Mr Andrew Driver
Development Manager NSW
Level 18, 2-12 Macquarie St
Parramatta New South Wales 2150

**Eastern Creek Resource Recovery Facility (SSD-9774)
Request Response to Submissions**

ATTACHMENT 1

ANNEXURE B: SWEPT PATH TESTING
(SHEET 1 OF 7)

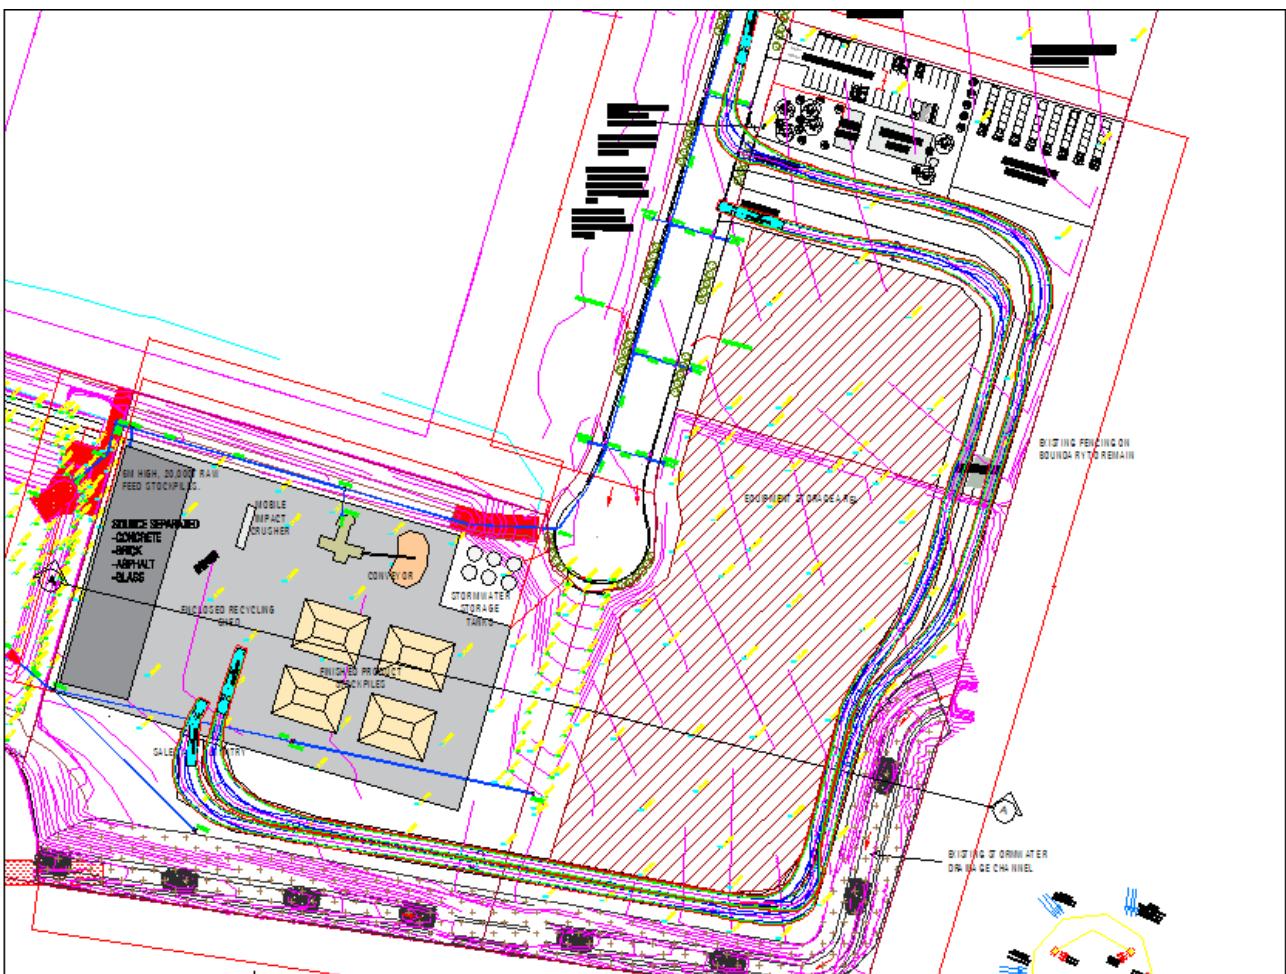
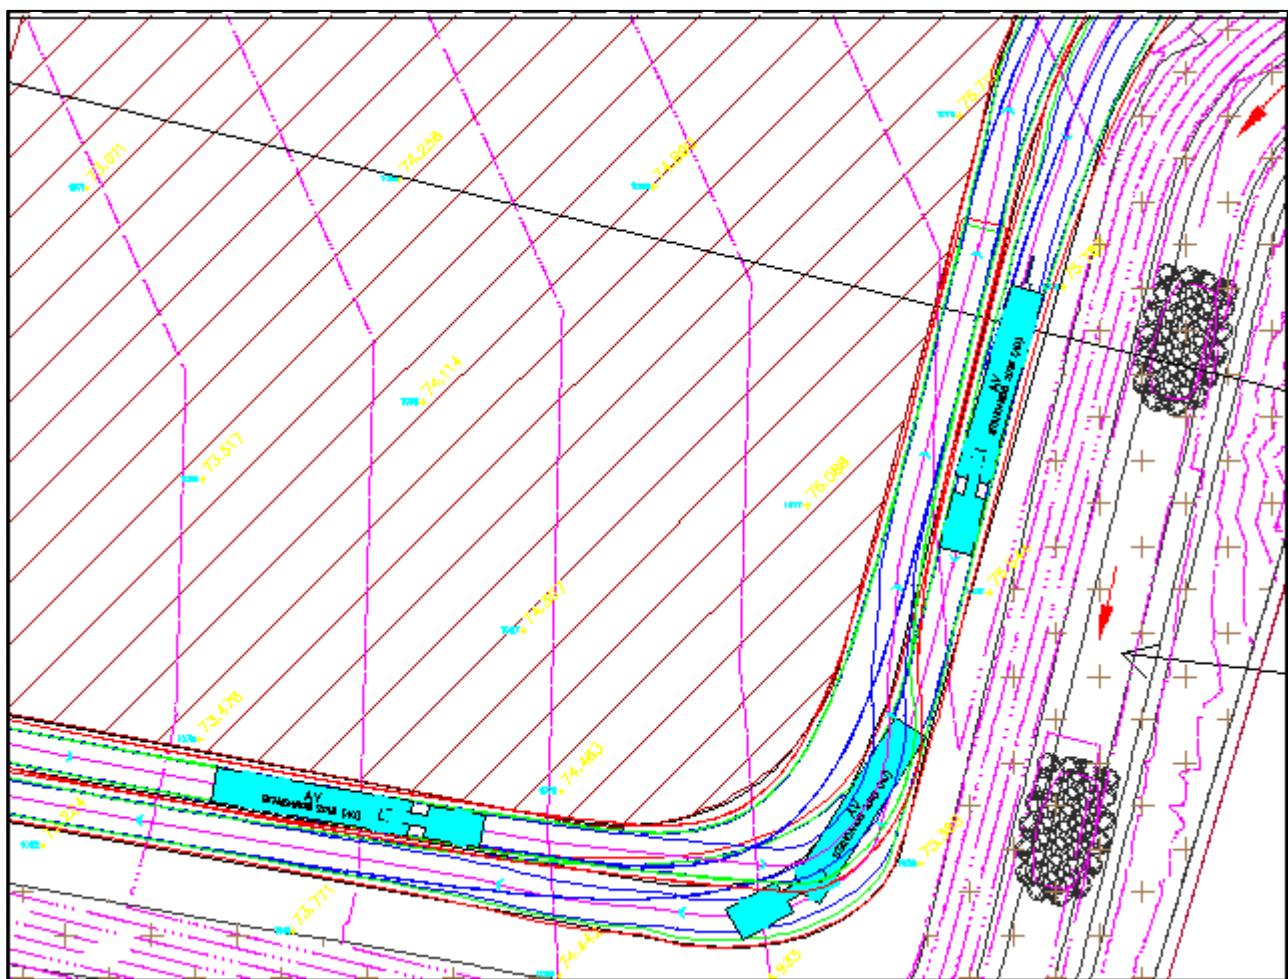
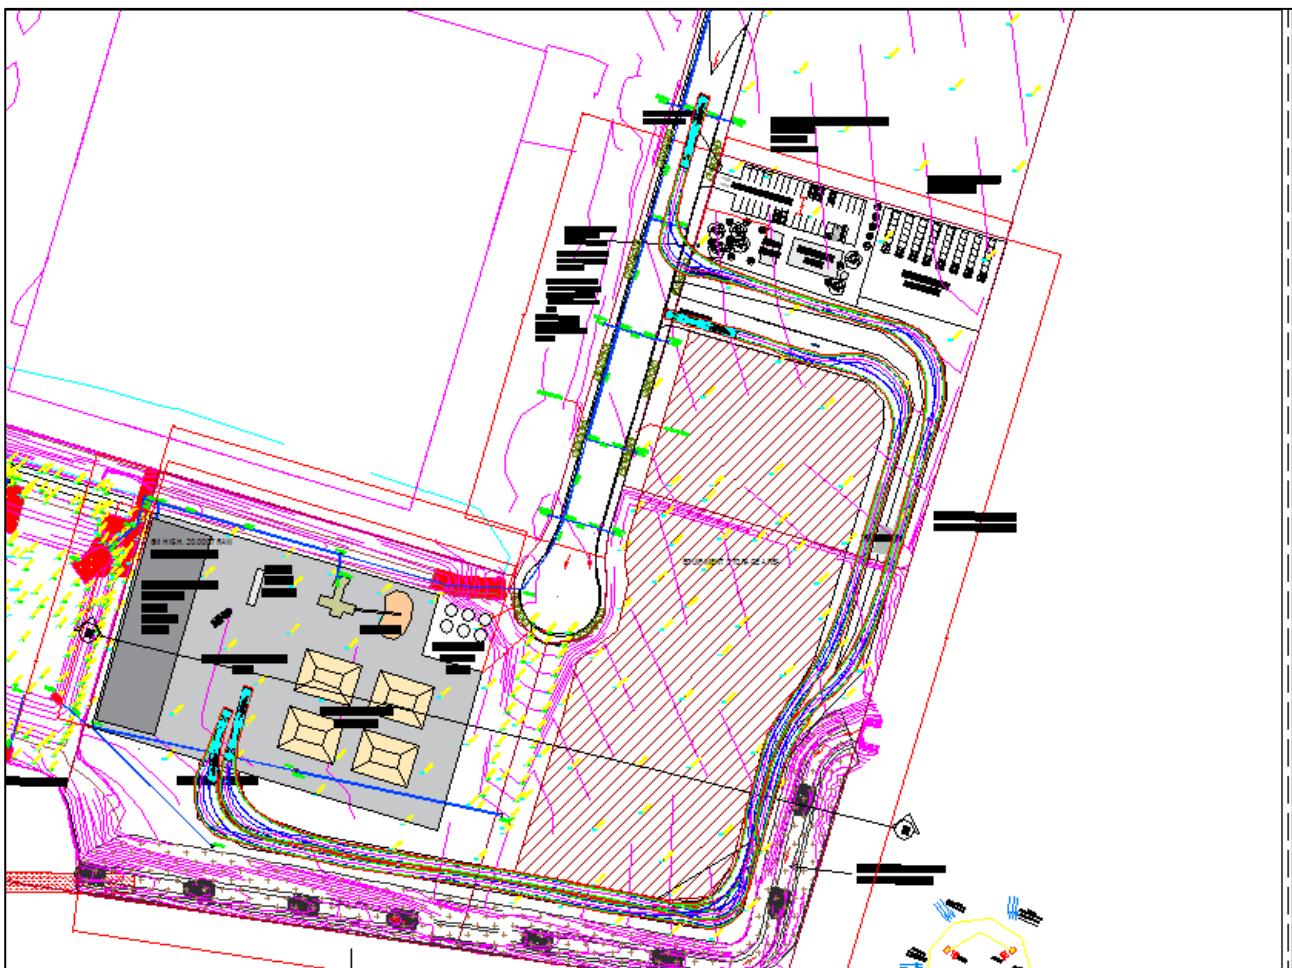
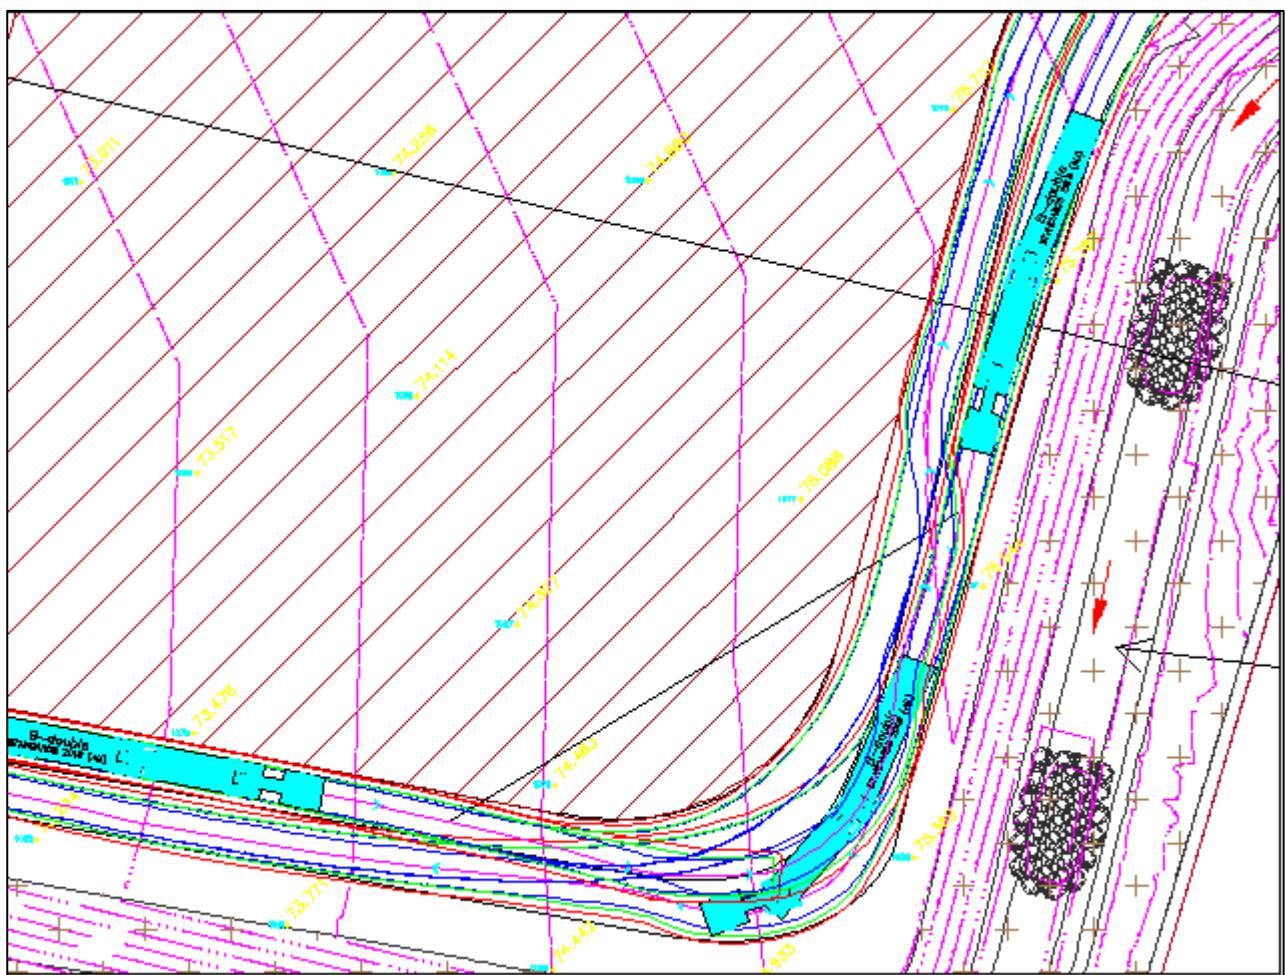
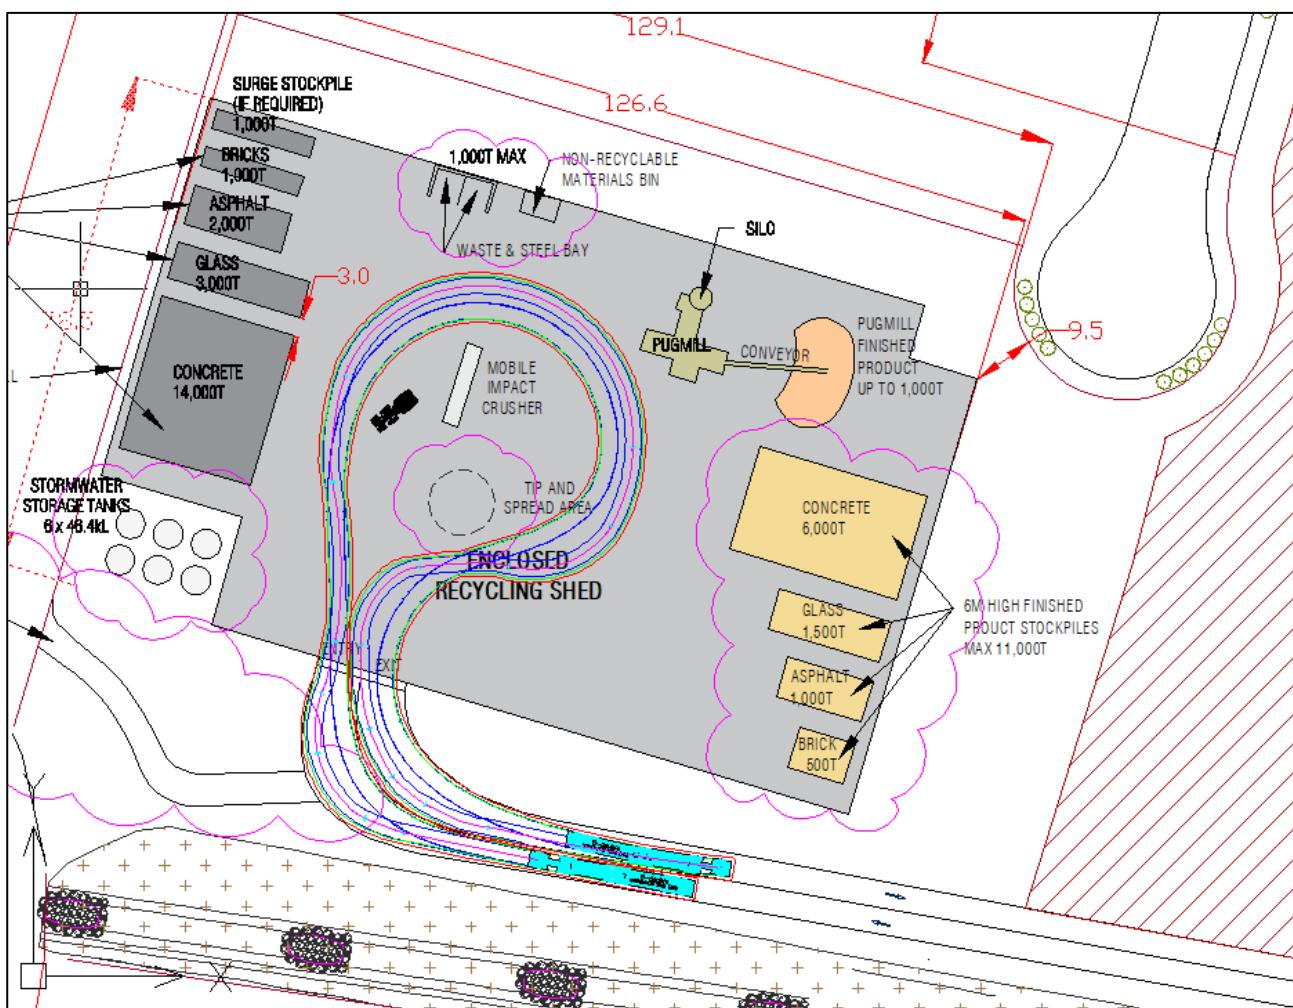
- Provide swept path diagrams that show the largest vehicles can:
 - safely pass while travelling around the site
 - enter and exit the truck parking safely
 - enter and exit the shed to receive and dispatch materials
- Describe how traffic would be controlled to effectively manage vehicles entering and exiting the site.

Title
 Site Plan
 Resource Recovery Facility
 Lot 3, 4 & 5 DP 1225803
 Hanson Place, Eastern Creek
 Alex Fraser Group

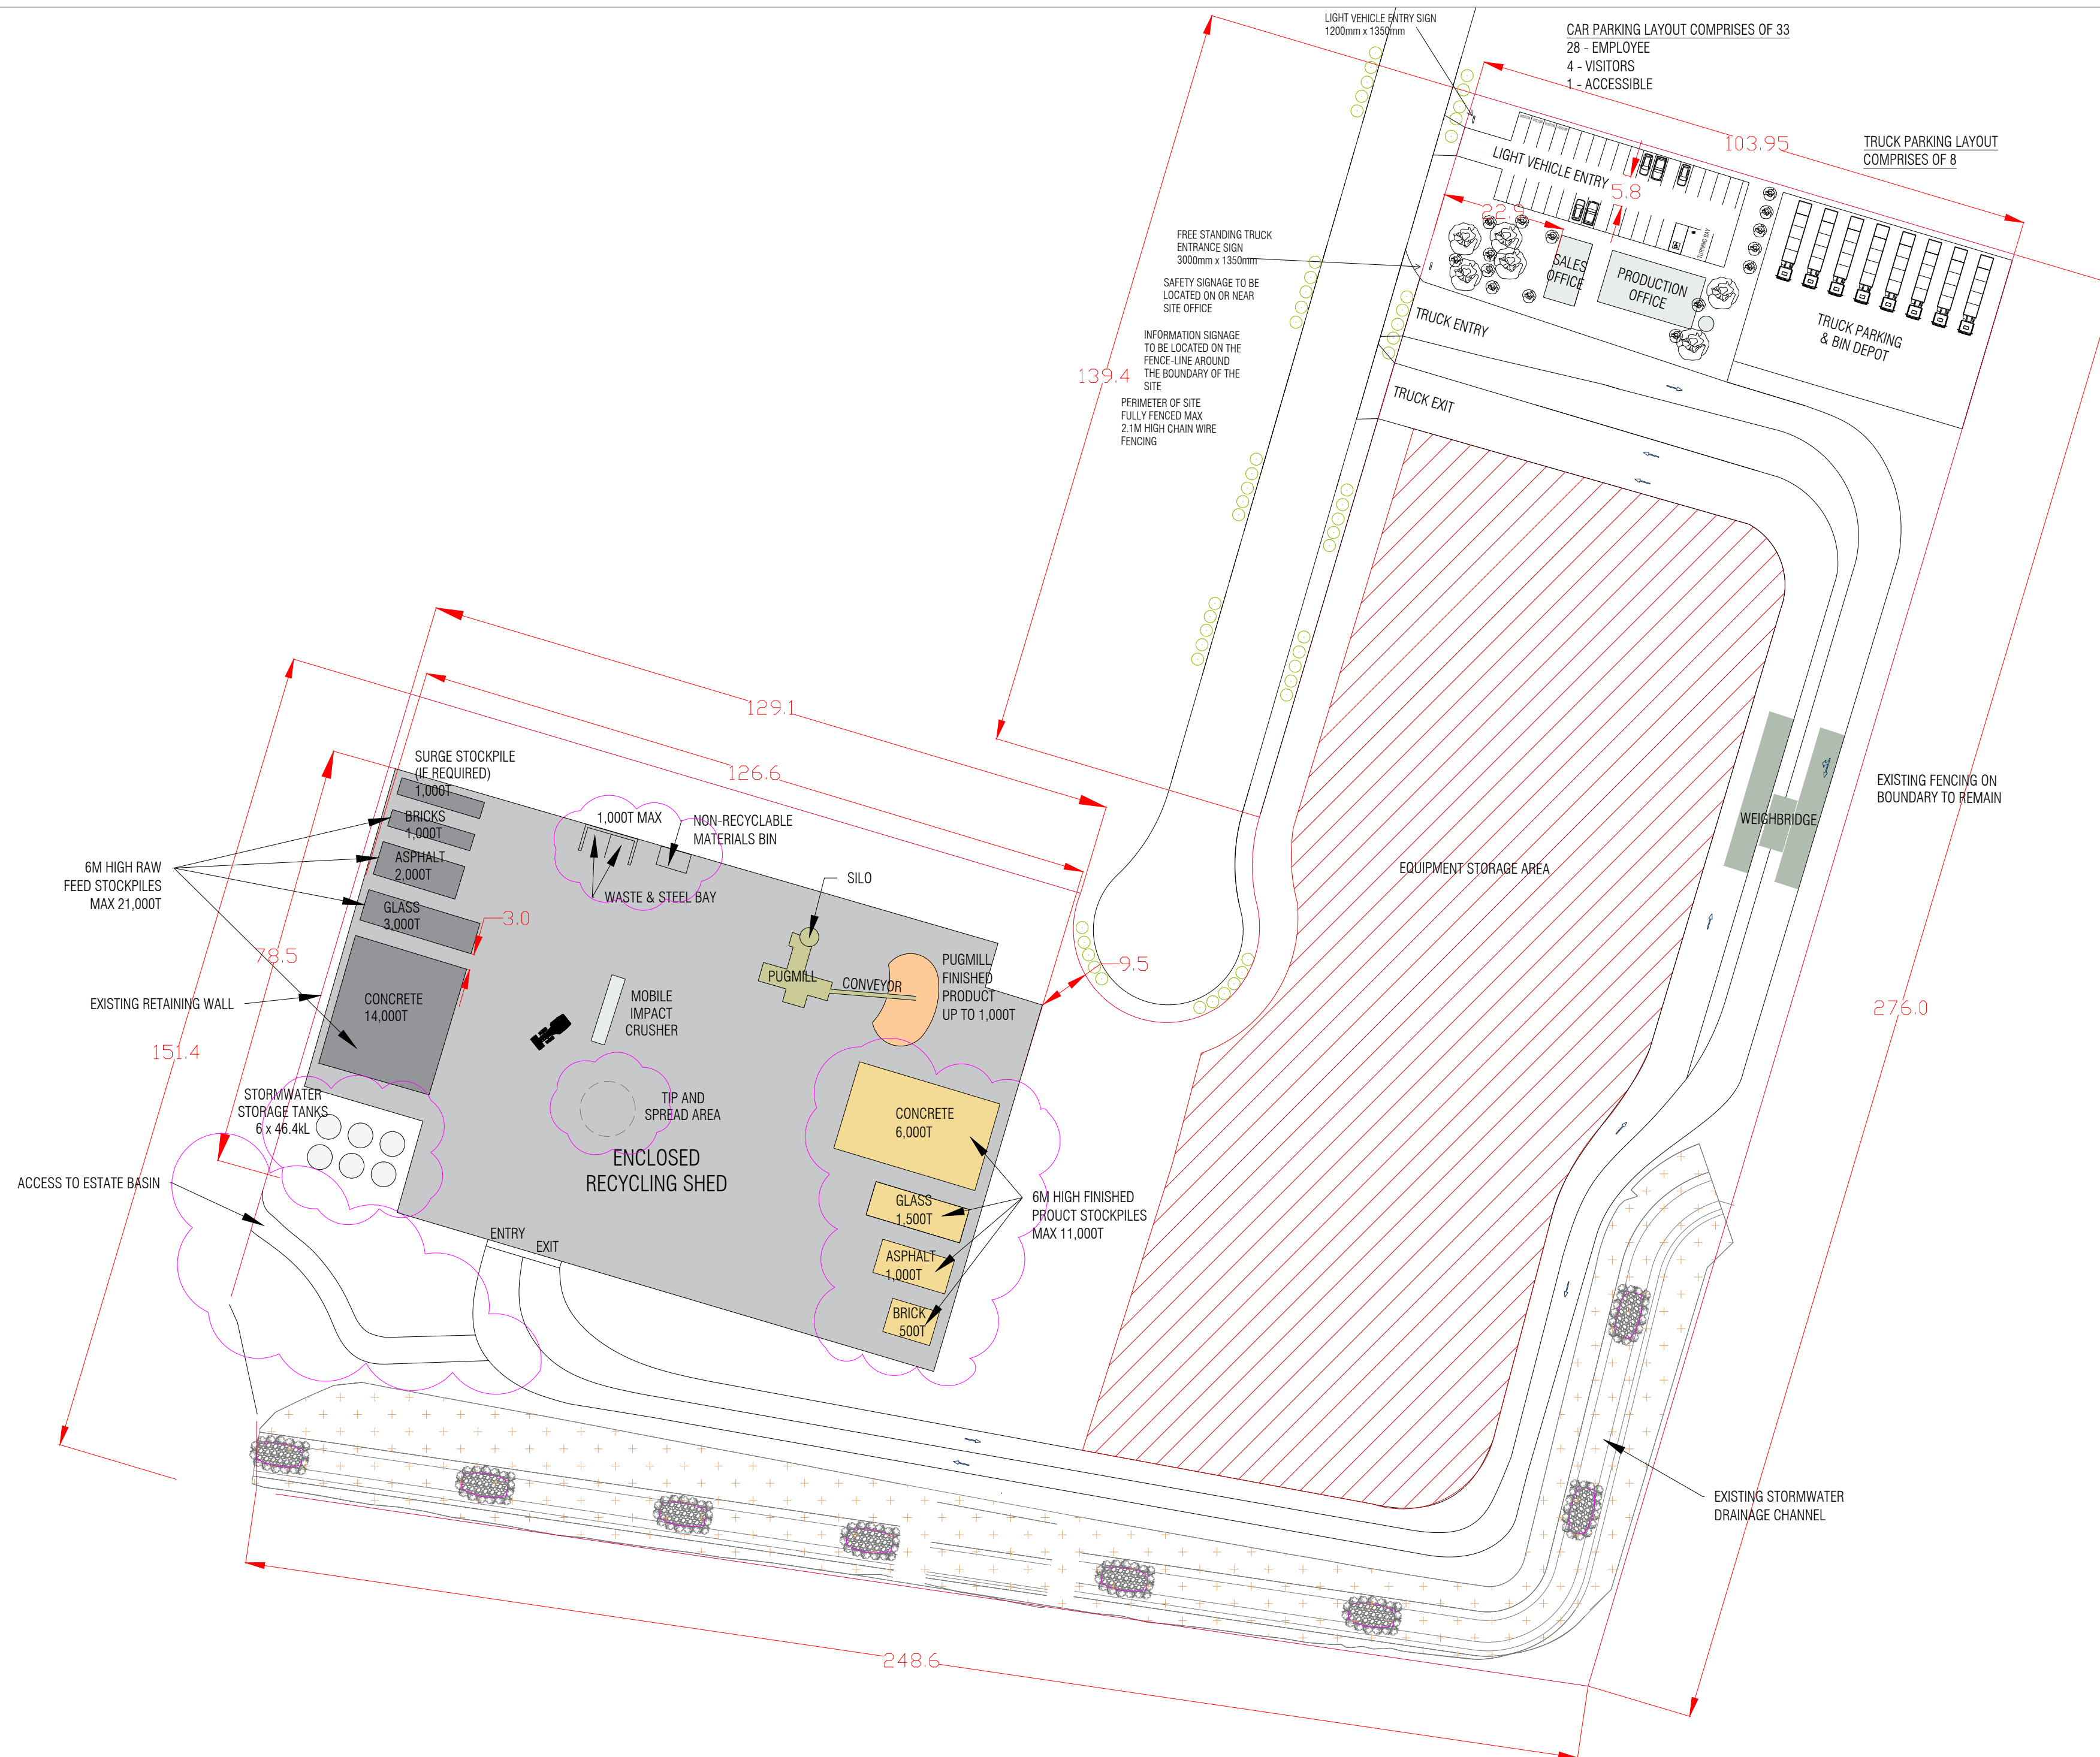
- Clearly label the waste and material product stockpiles on a plan and describe how these would be clearly delineated.
- Show where non-recyclable material would be stored and describe how often this would be removed.
- Confirm how material would be moved from the product stockpile to the pugmill (e.g. by conveyor or front-end loader (FEL)).
- Describe in more detail the range of output products and their end use or destination market.
- Confirm how outgoing trucks would be loaded e.g. by FEL.
